RE: Proposed Extensions

at 13 Parma Rise, Darfield

Planning Application Number 2010/0530

Proposed Side Elevation

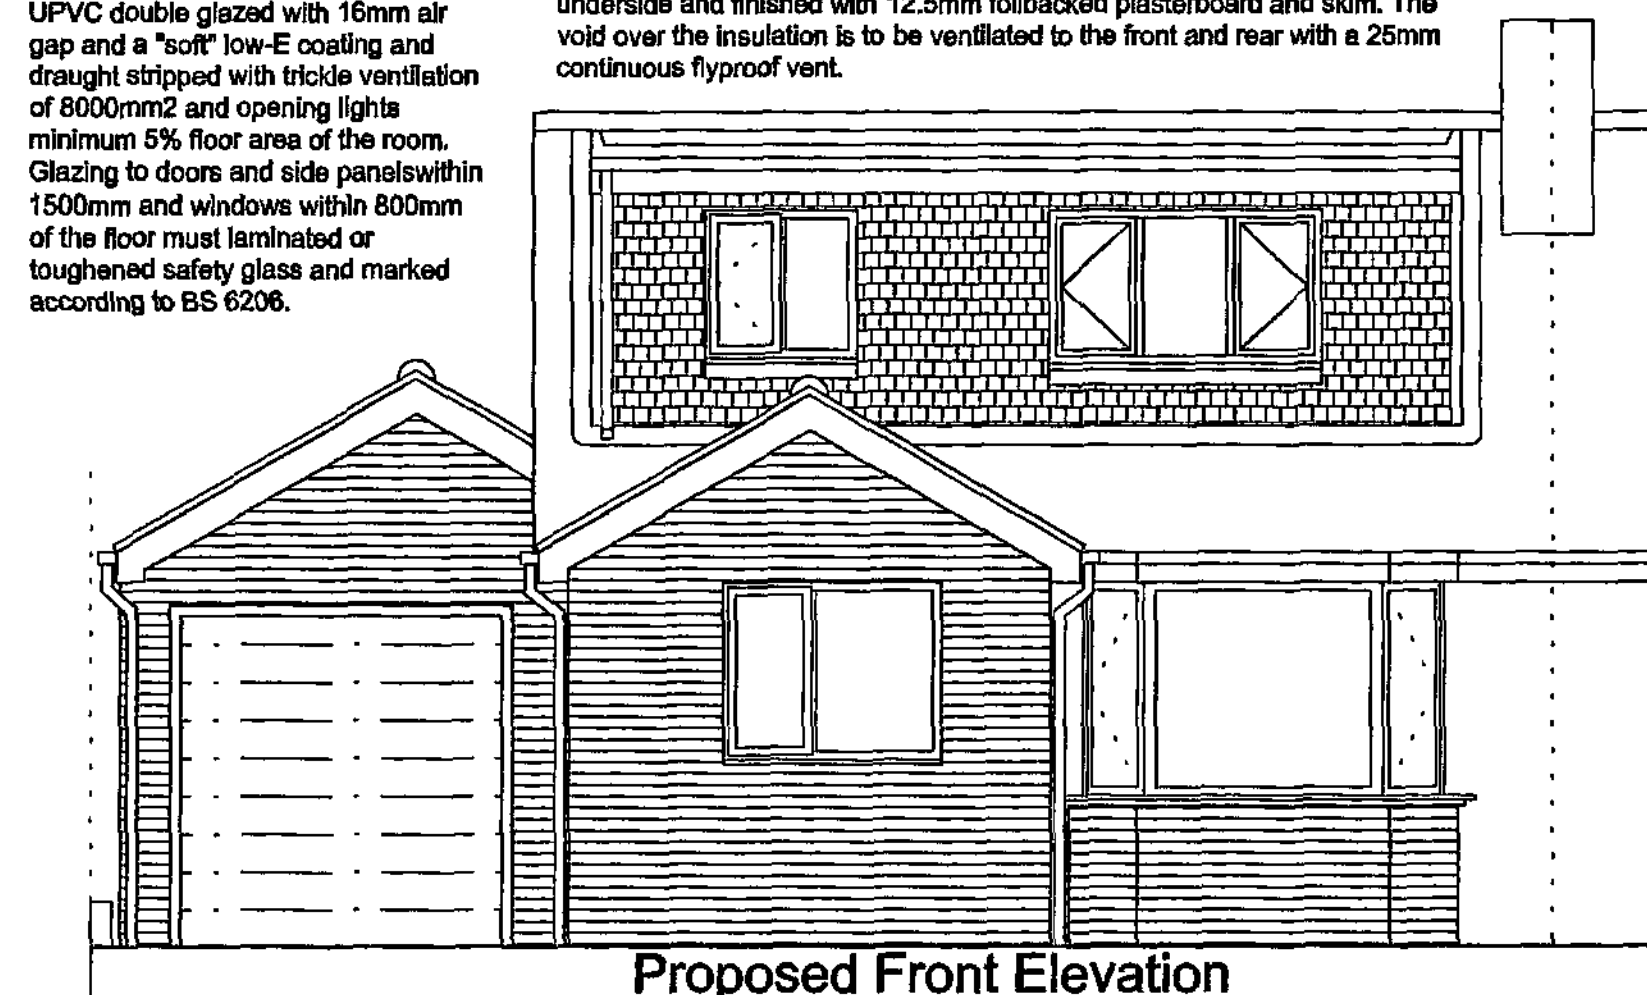
Point three, the garage roof has been altered to give the appearance of a detached garage.

Proposed Front Elevation

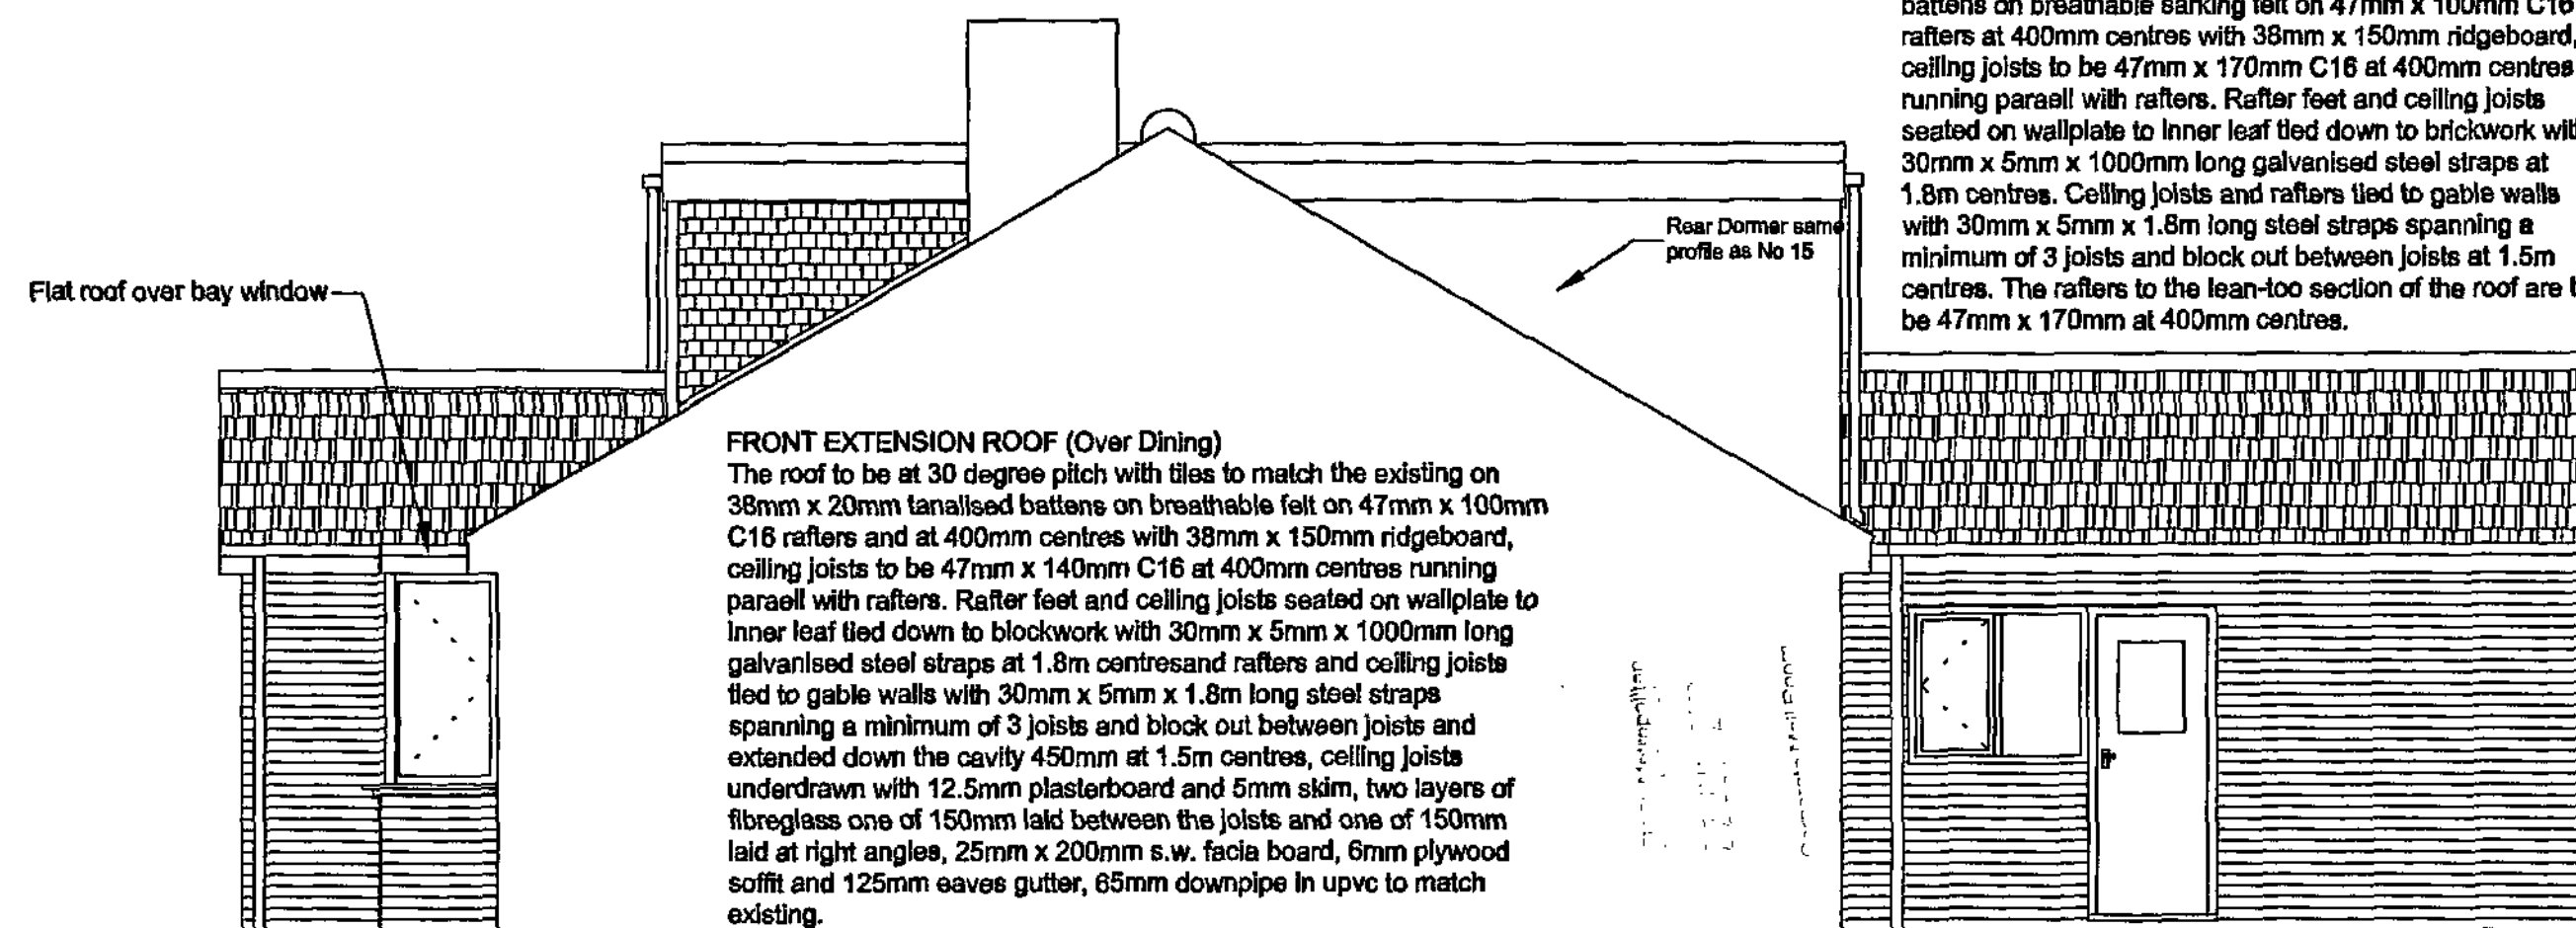
Point one, the pitched roof over the lounge window has been replaced with a flat roof.

Point two, the creation of two smaller dormers to the front elevation would create an impractical first floor layout by the division of the front bedroom; therefore this has not been altered on the plans. Numerous front dormer extensions of the same design has the submitted plans have been approved and built within this area including the one last year at 26 Lombard Crescent, the owner of which is the brother-in-law of the applicant.
